From: Sue Howell
Sent: 01 June 2015 17:21
To: Planning.Responses
Cc: Simon Davis
Subject: RE: Planning Consultation on P/36/15/DOC

APPLICATION NO: P/36/15/DOC

Site Address: Pagham Yacht Club Harbour/West Front Road
Pagham

Description of Works: Application for approval of matters reserved by condition imposed under P/12/14/ relating to condition 3 for landscape scheme.

Org. No.
14/02/01

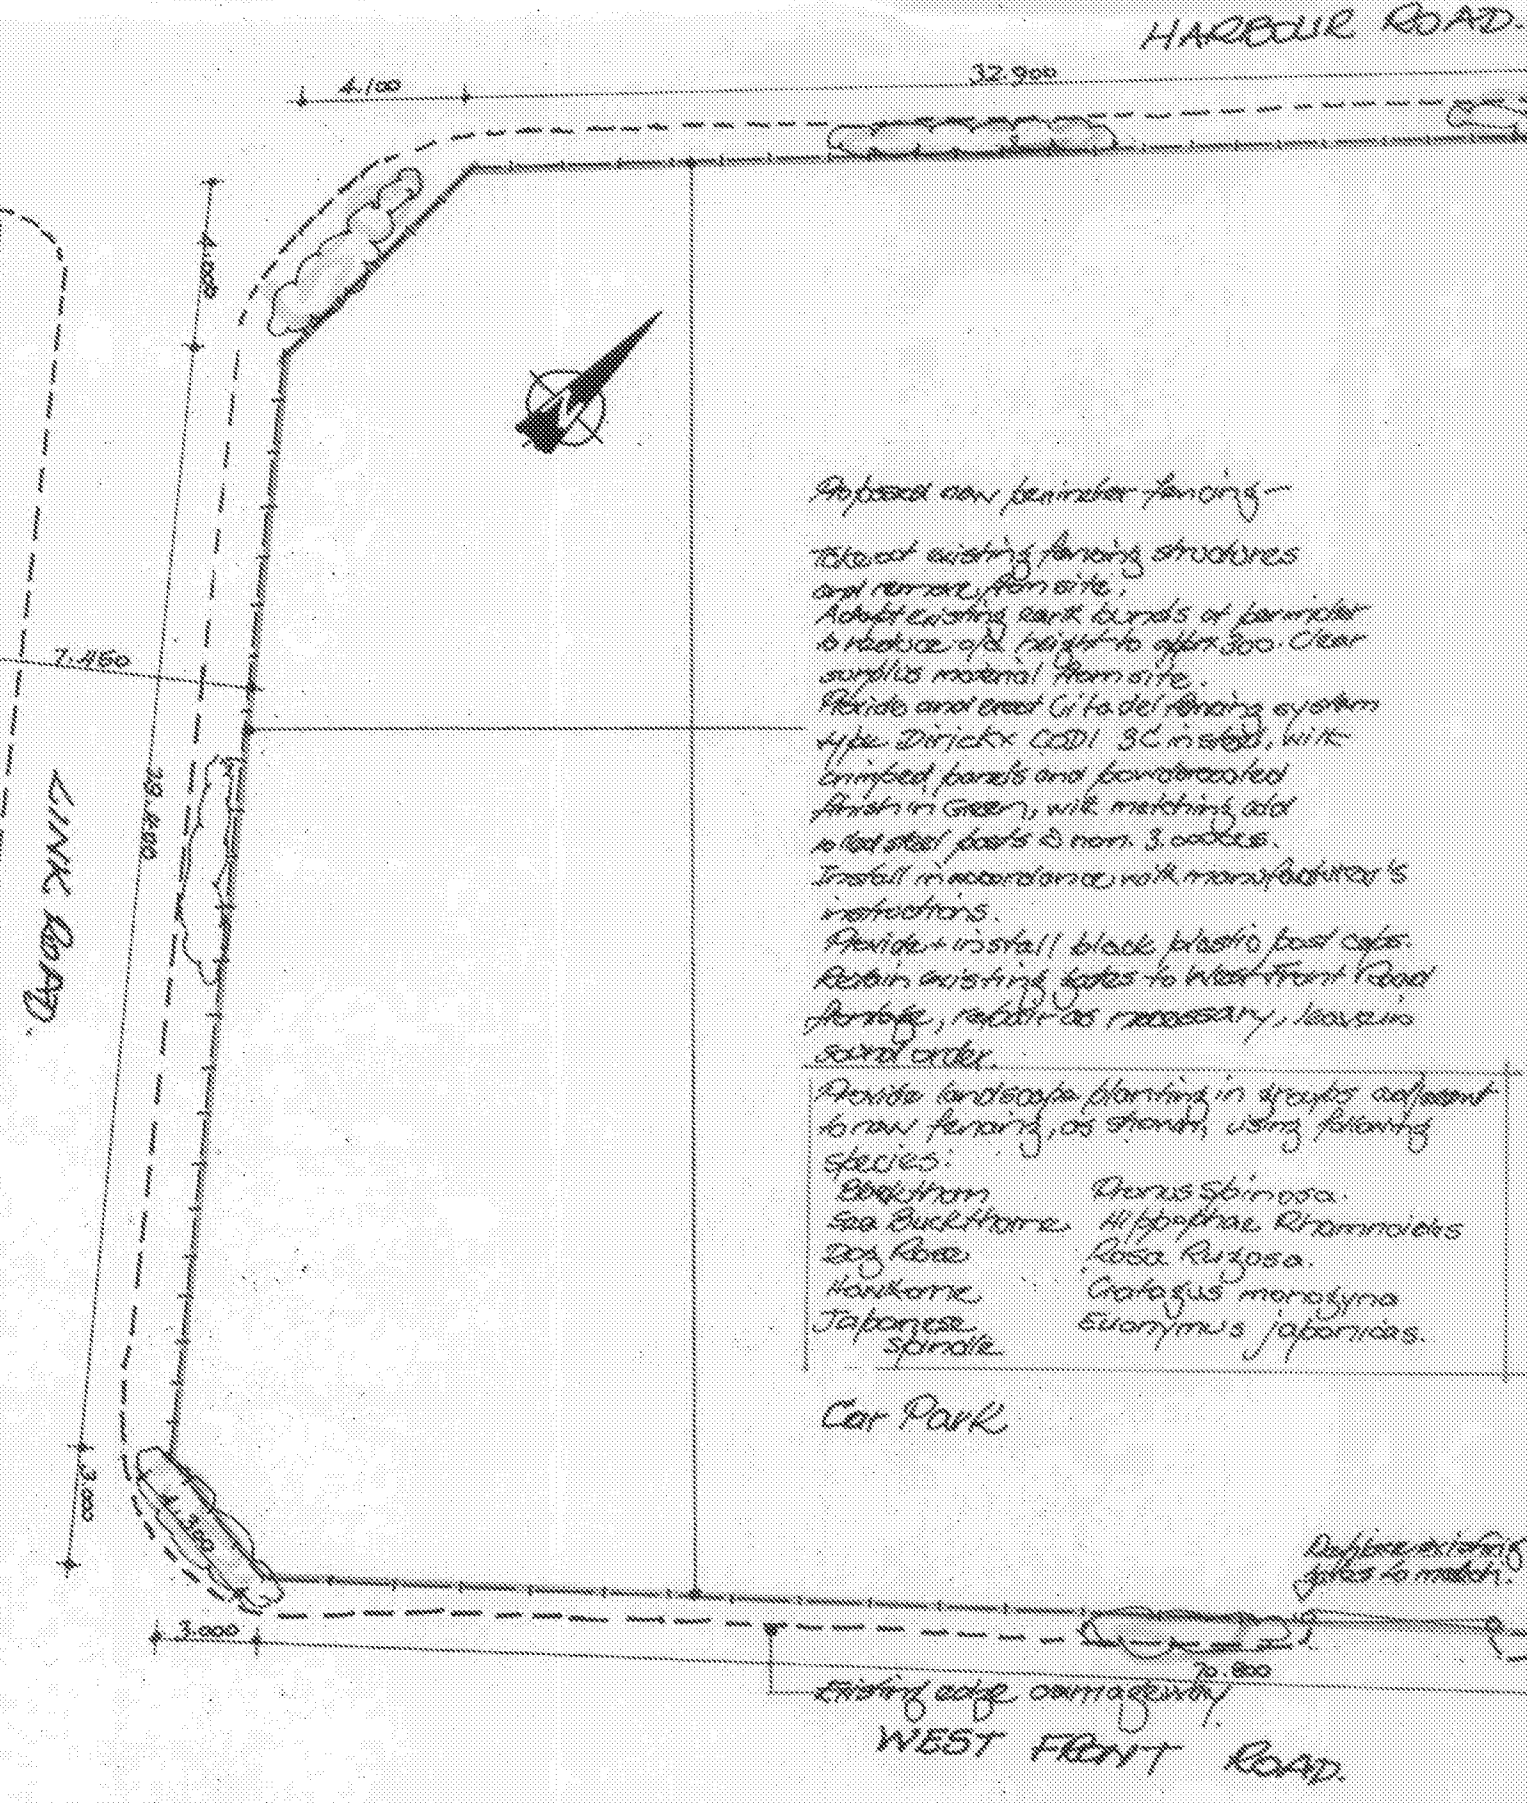
As the application P/12/14 was conditioned as below, we would require the information to be submitted giving detail of locations, quantities proposed, species choice, densities and size at time of planting. The revised dwg 14/02/01 Rev B gives this information in indicative form only.

We would recommend that this information is submitted and approved before we could recommend the discharge of Condition 3 on this application.
